**Application Reference: 3/2026/0144**

**Site: READ CRICKET CLUB, WHALLEY ROAD, READ BB12 7PN**

**Proposal: A proposed ball stop net**

**Sport England Reference: PA/26/NW/RV/73319**

Location Plan
1:1250 @ A4

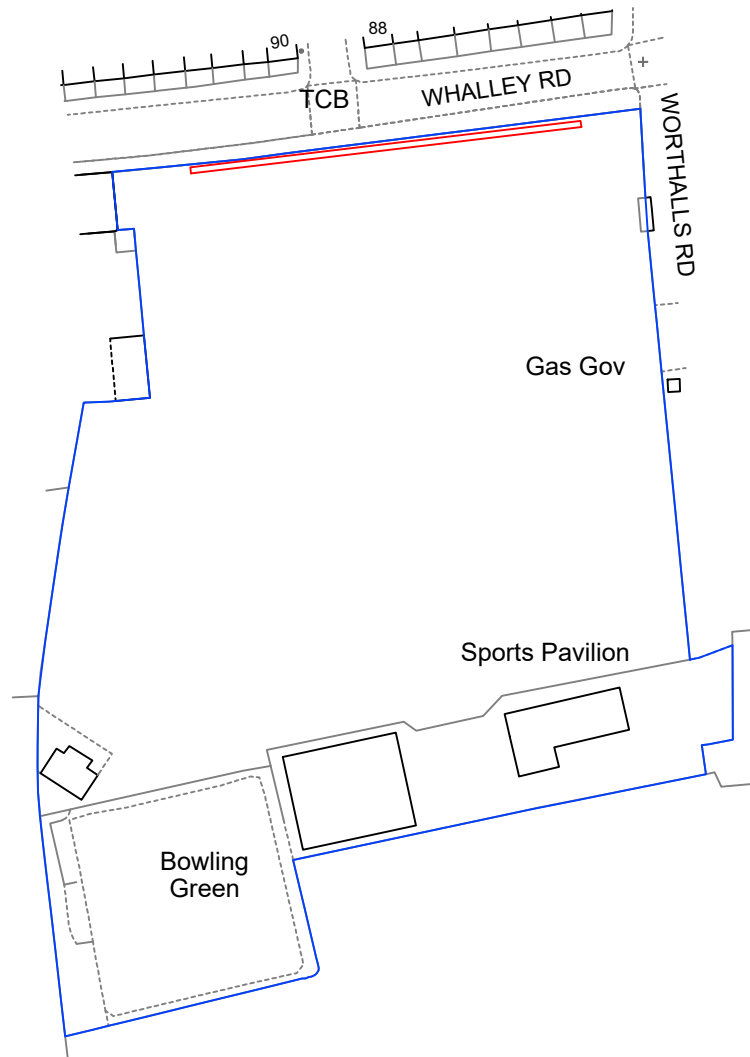
The proposal affects land which forms part of a cricket and bowling club. There is an additional pitch site to the south however this is not shown on the location plan and it is assumed that it does not form part of the cricket and bowling club playing field, rather is the separate playing field for Read Recreation Ground. The proposed ball stop fencing is proposed to be located to the north of the cricket pitch between the site and the northern boundary with Whalley Road. The facility is in association with and support the use of the site for the delivery of cricket.

There is no specific information as to the rationale justifying the netting system nor its precise location.

- *Site is the home of Read CC which has 3 senior teams and 3 junior teams.*
- *Unable to assess at present. Whilst there is a diagram showing the plan, there is no indication as to how the height of the fence has been determined and given the tight space between playing field and existing wall, we would need to know where the fence will be erected.*
- *The ECB is happy to work with the club around finding a solution*

Sport England will require further information in order to fully assess the proposal in terms of justification for the type and height of system shown and its location on the cricket pitch in plan form to indicate the distance between the fencing and pitch boundary and/or wicket.

- Provision of justification for the type and height of fencing system proposed – has a ball strike assessment been undertaken?
- Provision of a drawing to show the impact on the cricket pitch – proximity of the fencing to the cricket boundary and wicket.
- The applicant should contact the ECB to discuss how to progress their proposal  
contact email: [Richard.dixon@ecb.co.uk](mailto:Richard.dixon@ecb.co.uk)
